APPLICATION CONSULTATION RESPONSE

Application Number:	3/2017/0317
Location:	Land south of Blackburn Road, Hothersall PR3 2YY
Grid Ref:	E 361763, N 437185
Proposal:	Outline planning application for employment floorspace (use classes B1, B2 and B8) and associated access, car parking, landscaping and services infrastructure with all matters reserved except for access

Figure 2 – Proposed Site Plan

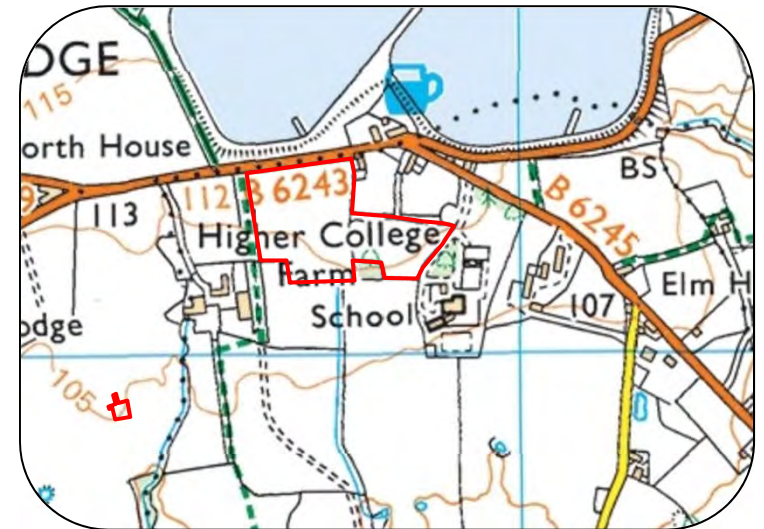
It is evident from the FRA & Drainage Strategy T2267-FRA-01 Nov 2016 that the applicant intends to discharge surface water to a watercourse possibly via the existing pond on site.

Confirmation that an agreement is place to allow the surface water to be discharged to the watercourse near the southern boundary is required as the watercourse is outside the red line boundary.

The FRA & Drainage Strategy considers utilising the existing pond as a surface water discharge point based on an assumption that the pond may outfall to the

unnamed watercourse near the southern boundary. This unidentified culvert which connects the pond to the watercourse has the potential to cause a flood risk as it is unidentified and unaccounted for in the drainage design and layout of development proposal.

It is therefore asked that the applicant identifies the current location of the unidentified culvert to ensure that it is appropriately accounted for and considered in the sustainable drainage design for the development proposal.
